REQUEST

Current Zoning: N-1 A (Neighborhood 1-A)
Proposed Zoning: B-2(CD) LWPA (general business, conditional, Lake Wylie Protected Area)

Approximately 1.66 acres located on the south side of Mt Holly-Huntersville Rd between Bellhaven Blvd and Abbington Holly Dr.

The petition proposes to redevelop a site in the Coulwood neighborhood with a carwash including 4,500 square feet of gross floor area and accessory uses permitted in the B-2 district.

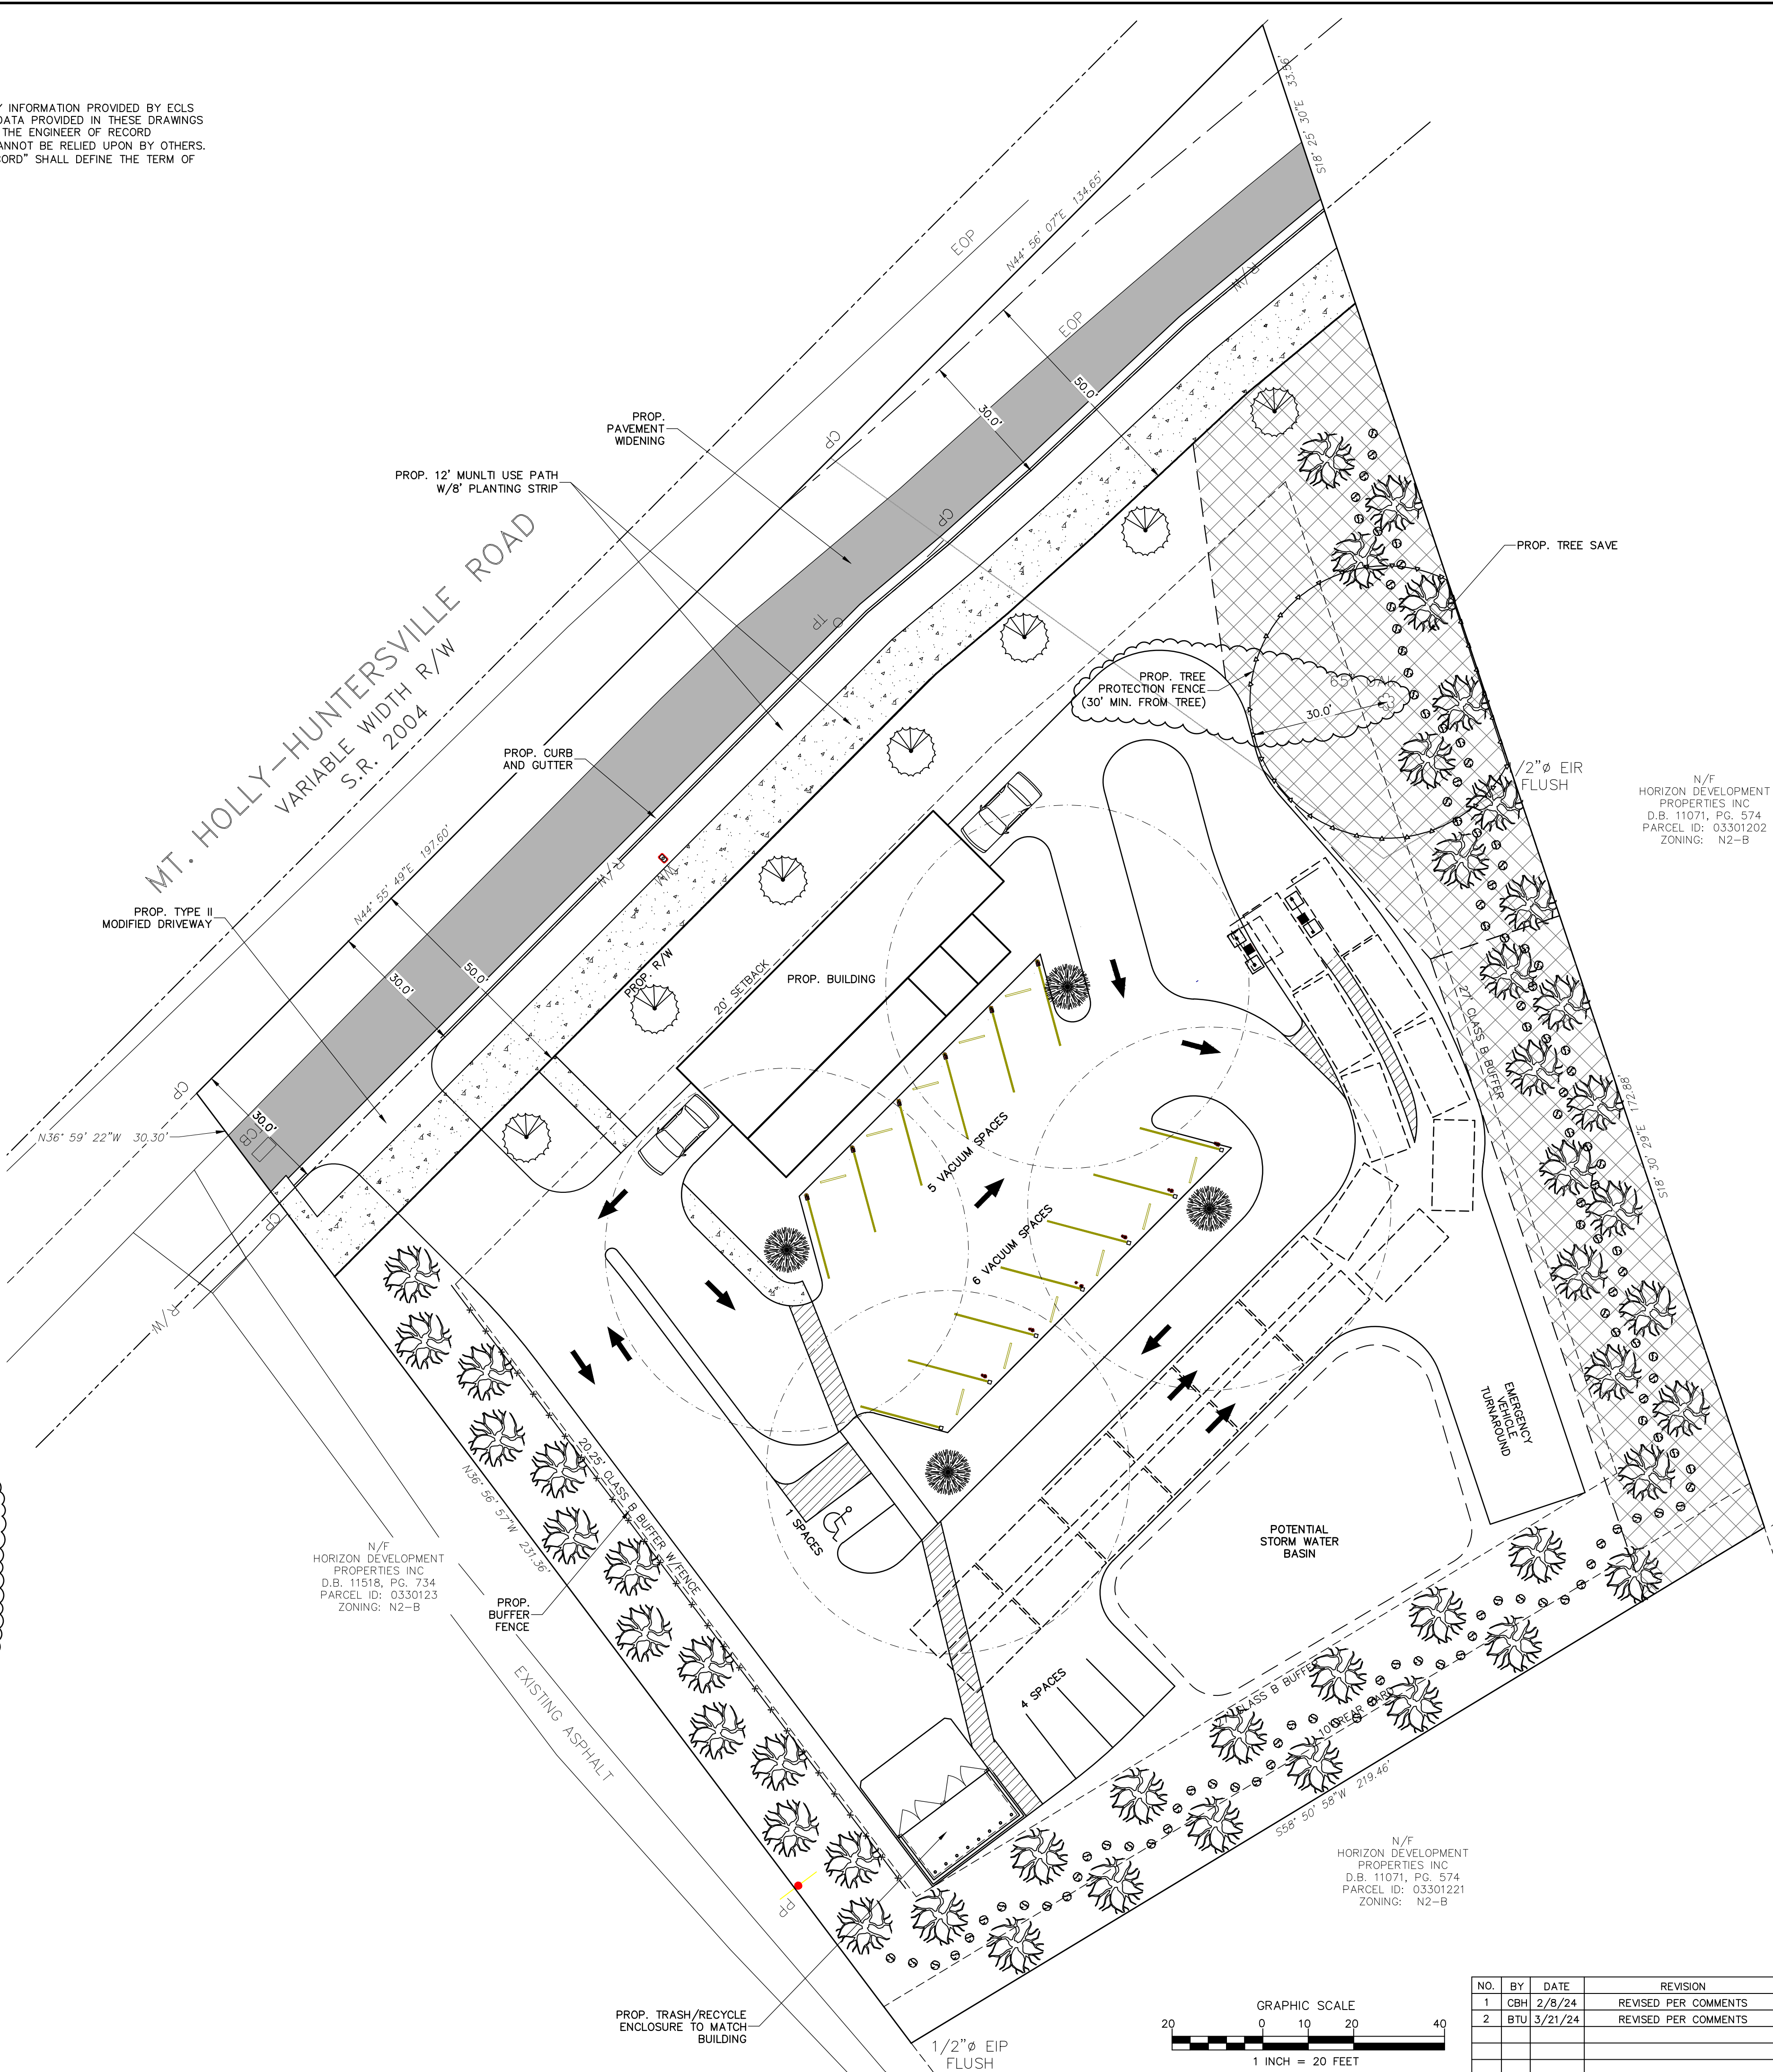
- ~~1. Remove note 5.b. stating that the 6' sidewalk and varied width planting strip along Mount Holly Huntersville will remain. This conflicts with note 5.d. stating that an 8' planting strip and 12' multi-use path will be constructed.~~ **ADDRESSED**

- ~~2. Add conditional note stating that the petitioner will make a concerted effort to preserve the 65" oak tree on site.~~ **ADDRESSED**
